**DECISION DELEGATED TO HEAD OF PLANNING**

**Application No:** H09-0796-25                      **Applicant:** Loosegate Developments Ltd

**Proposal:** Proposed Erection of 2 Bungalows

**Location:** Land East Of Forest Way Holbeach Spalding

DRAWING NUMBER | LDC4657 - 04

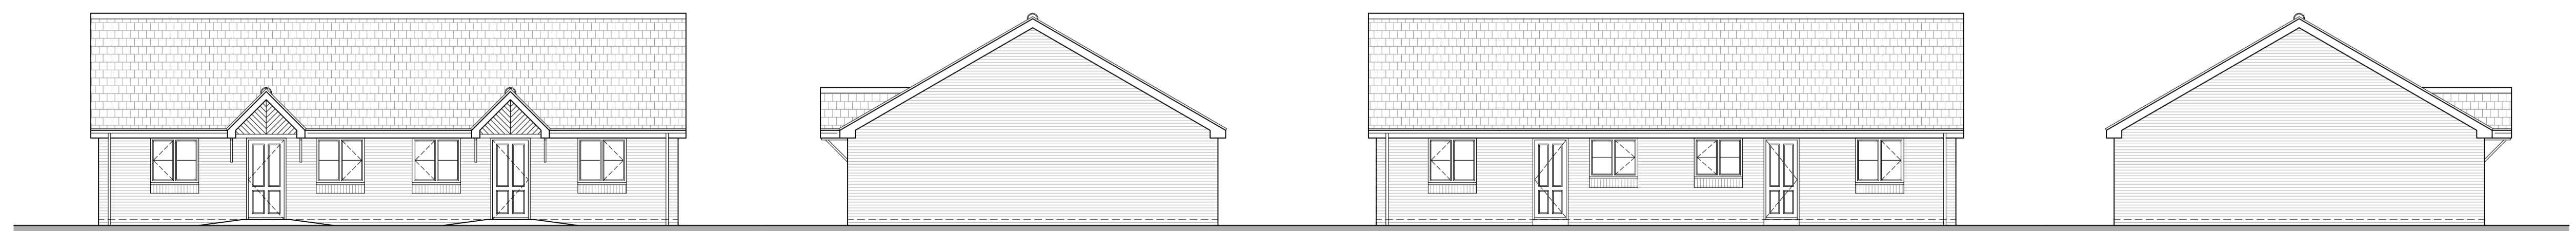
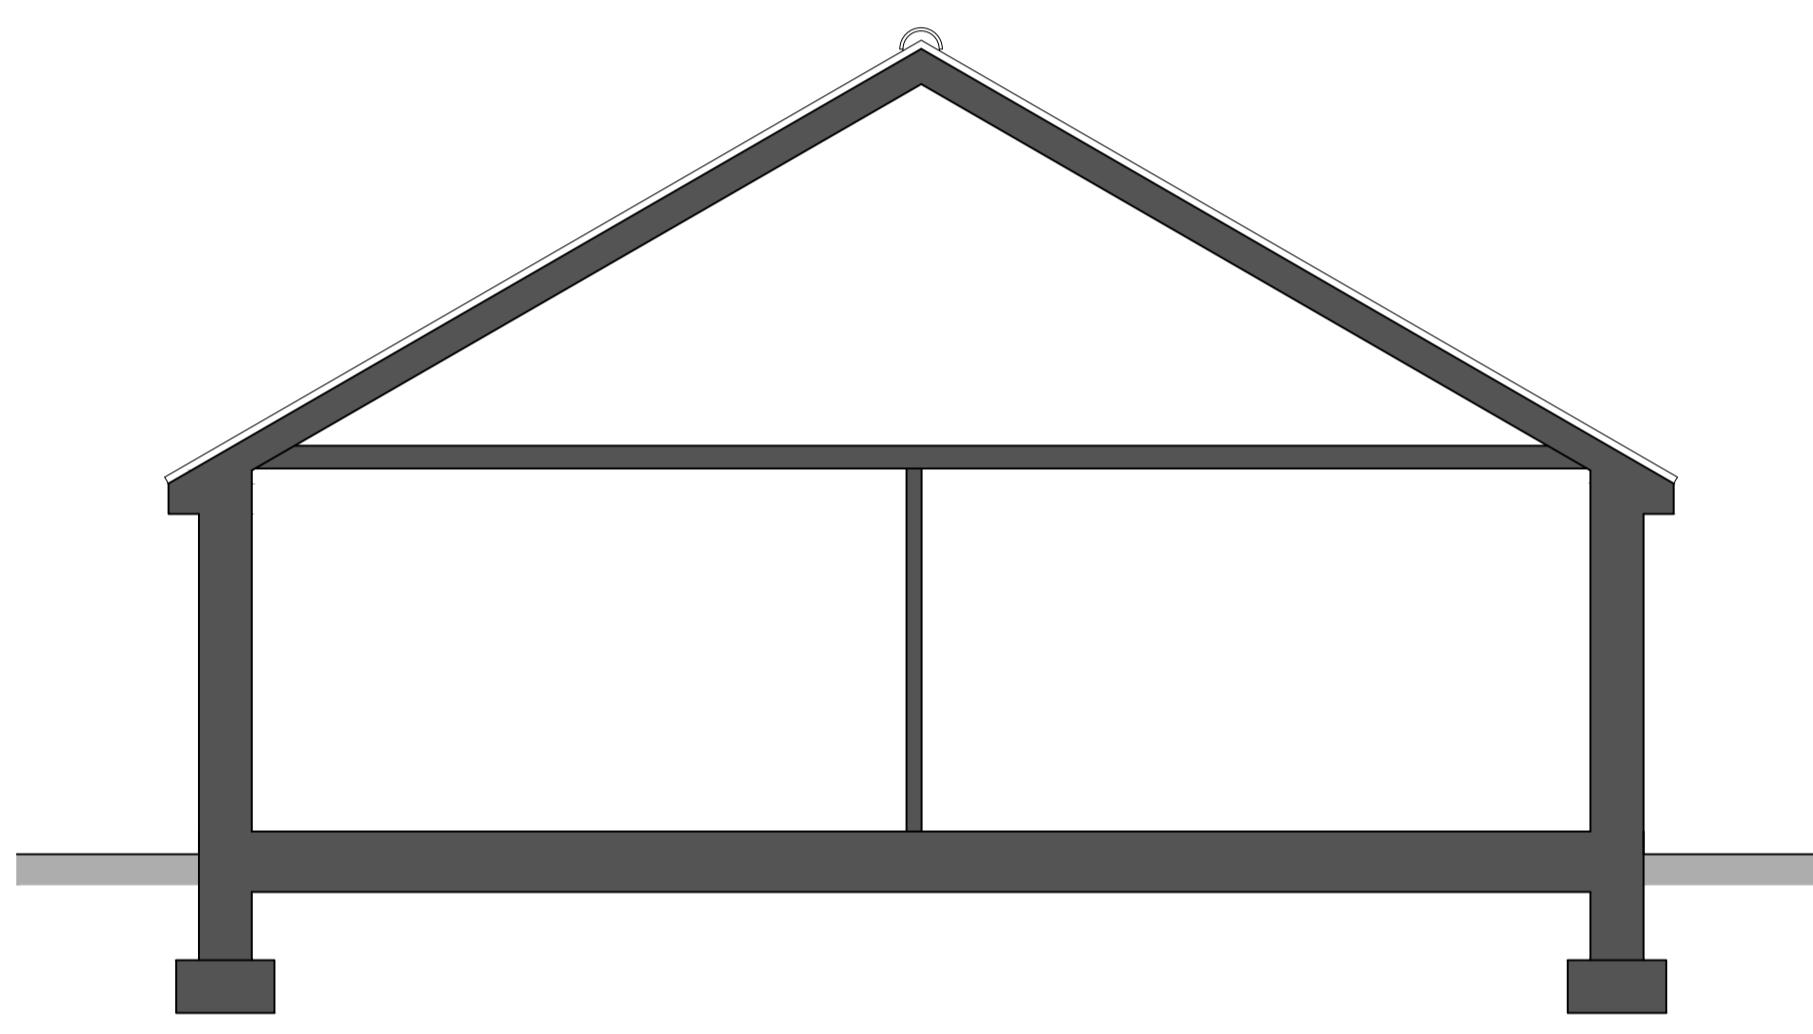
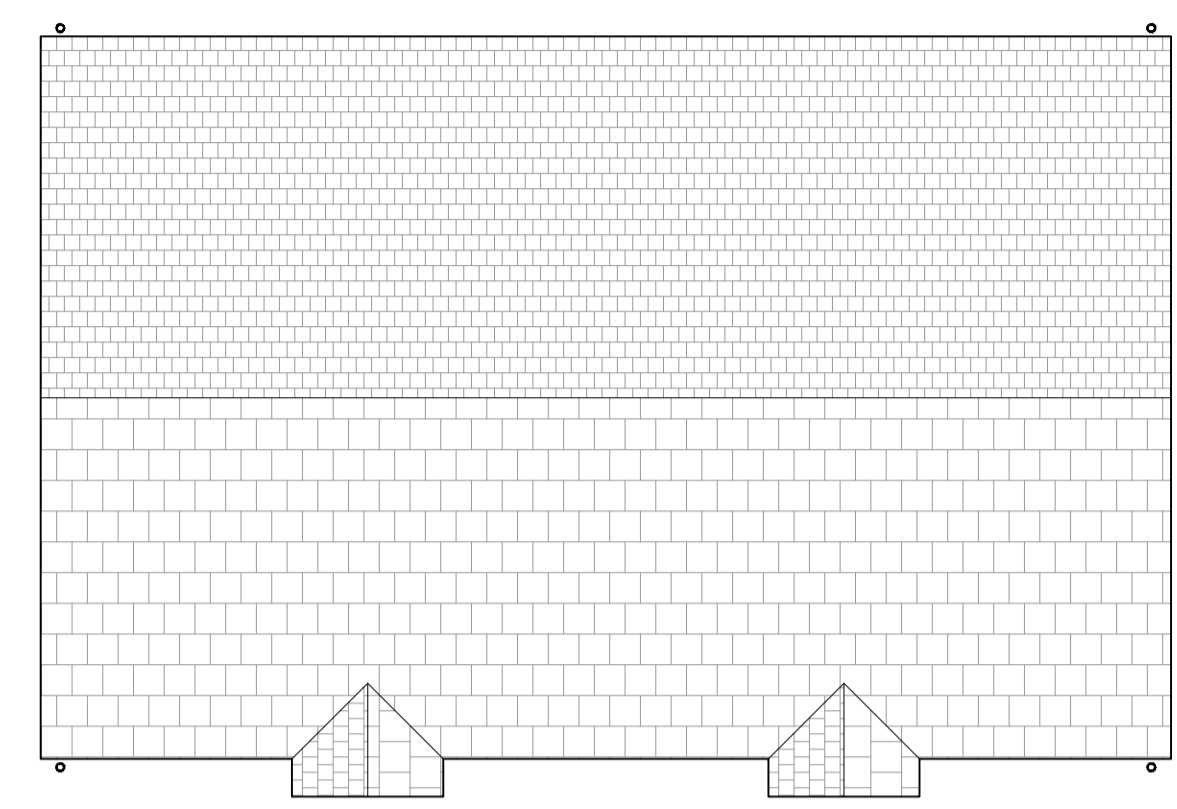
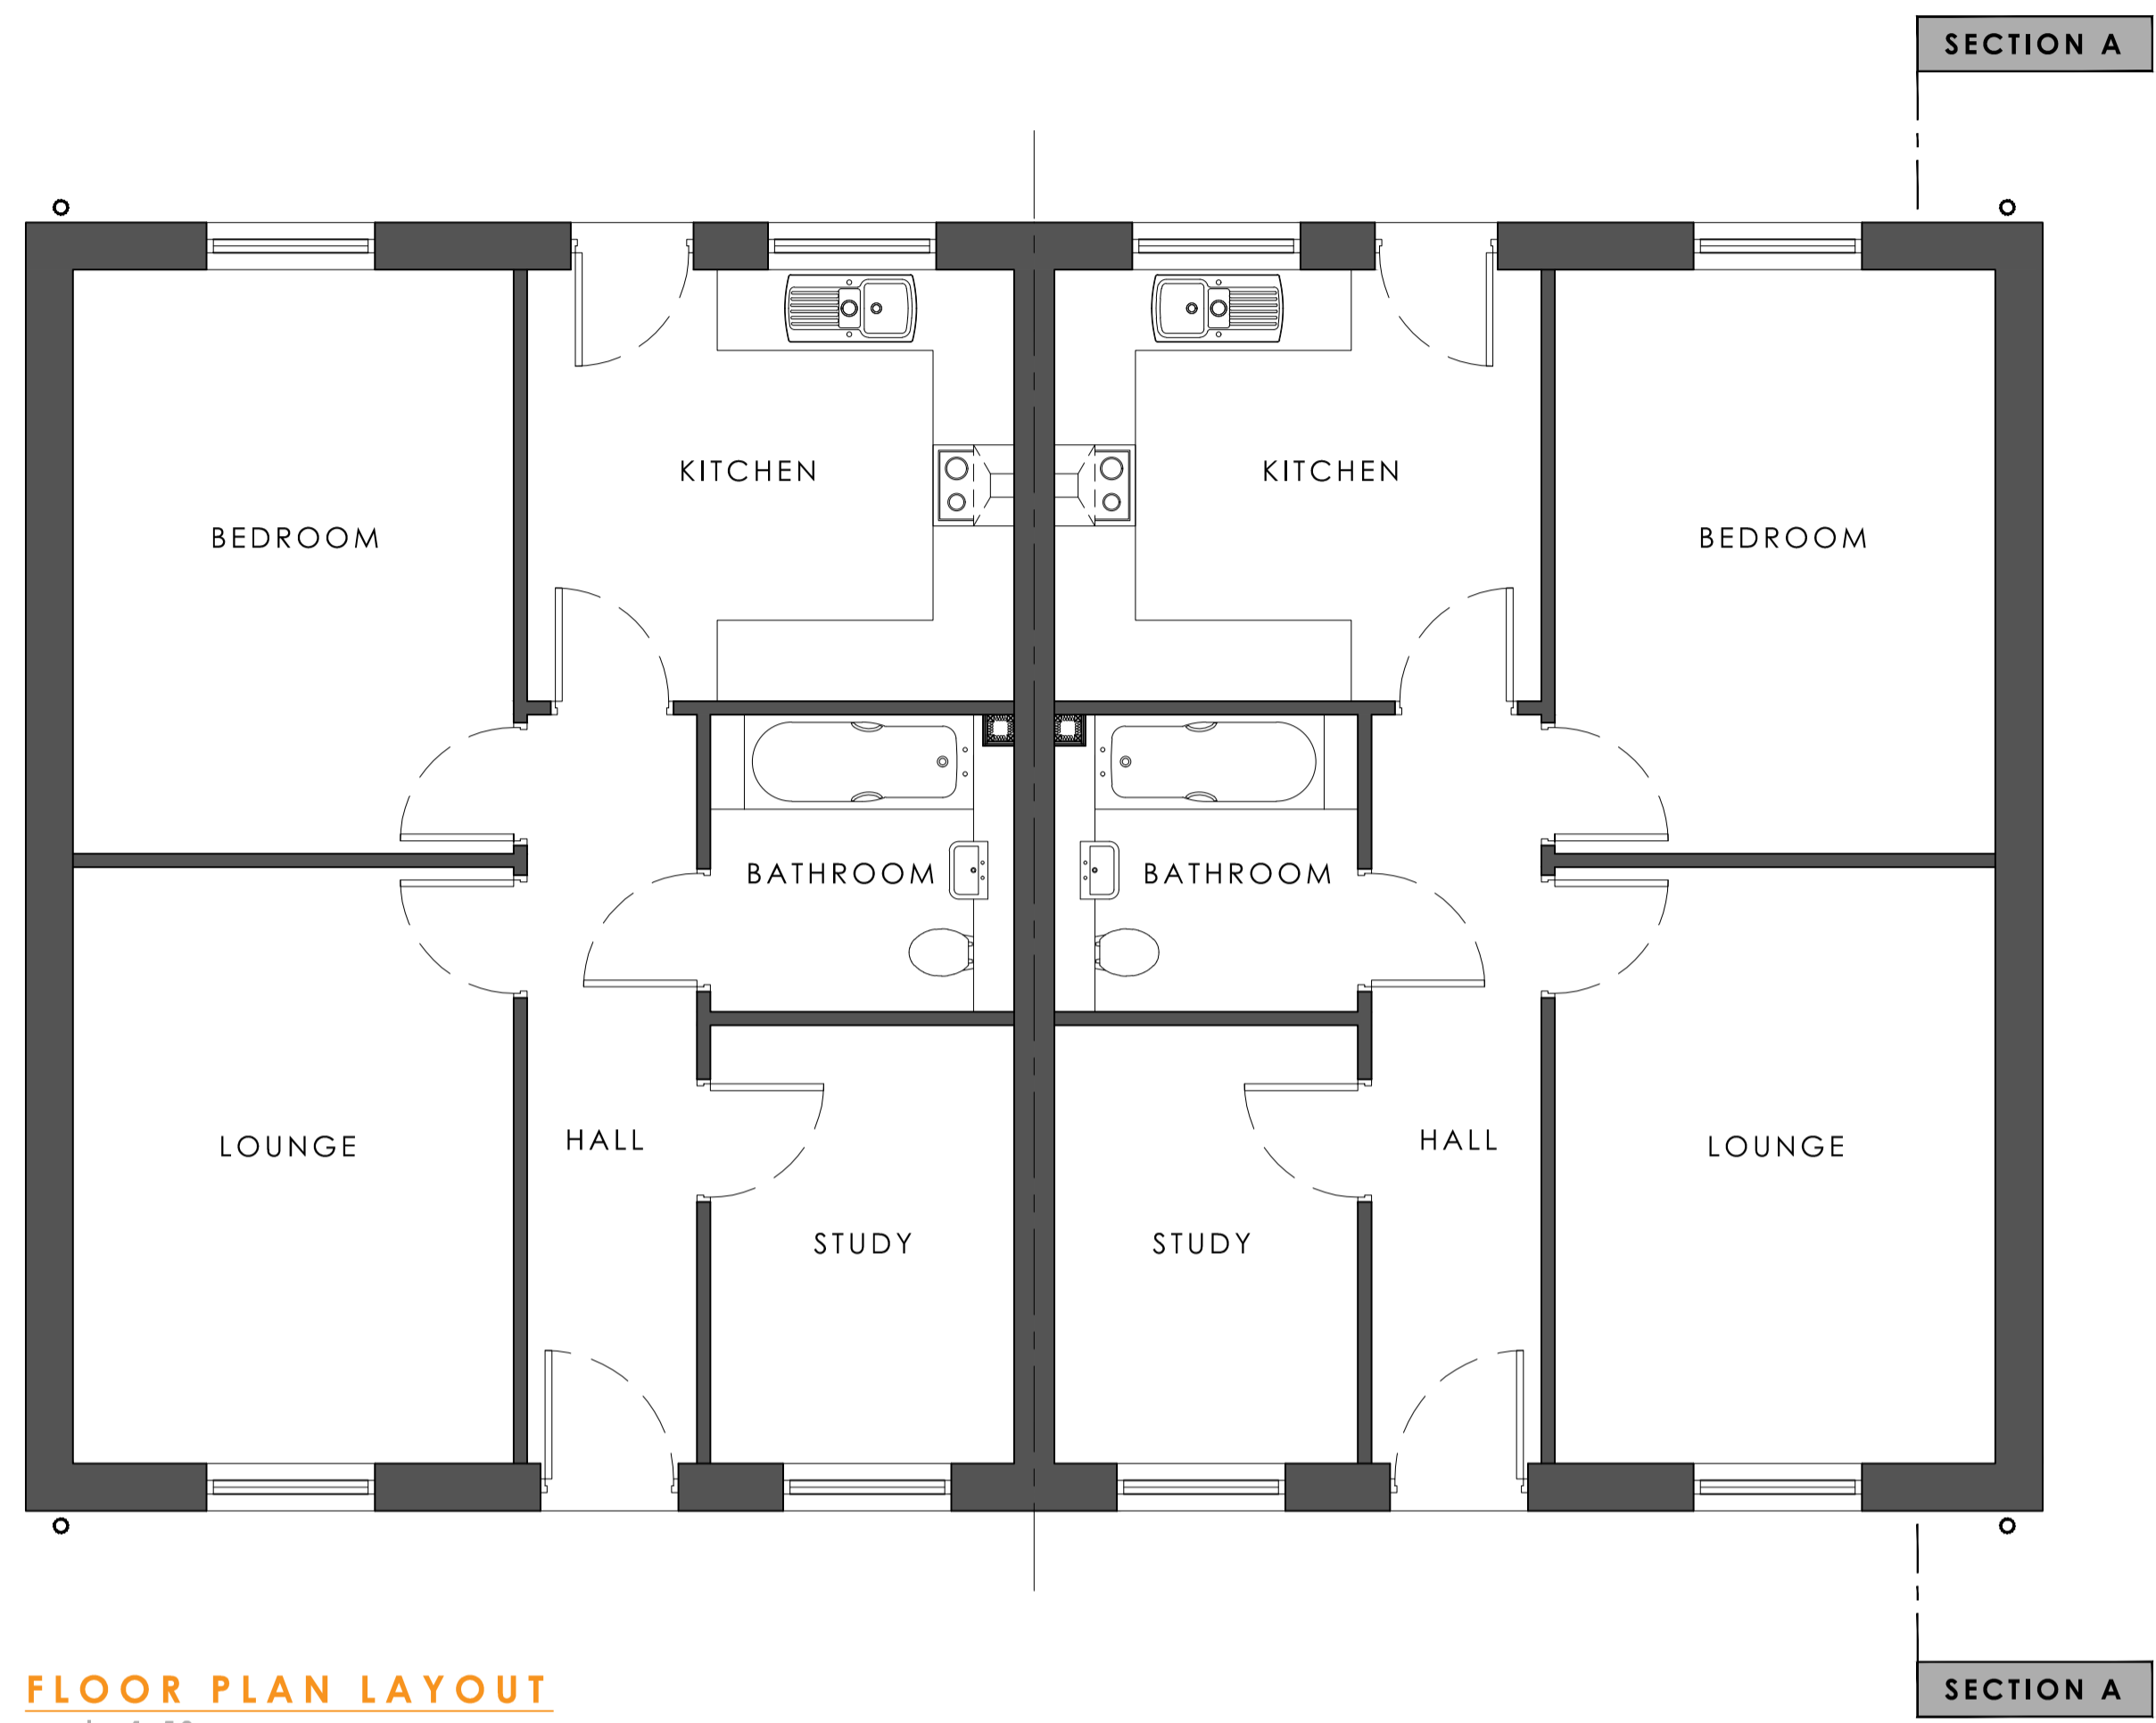
The bungalows are proposed to be semi-detached, featuring a gable end roof form and two porch roofs on the front roof slopes. The bungalows feature symmetrical facades. The ridgeline height of the bungalows measures 5.5m and the eaves measure 2.5m in height. Although the proposed materials are not yet confirmed, the plans show brick soldier course detailing beneath the windows on the bungalows.
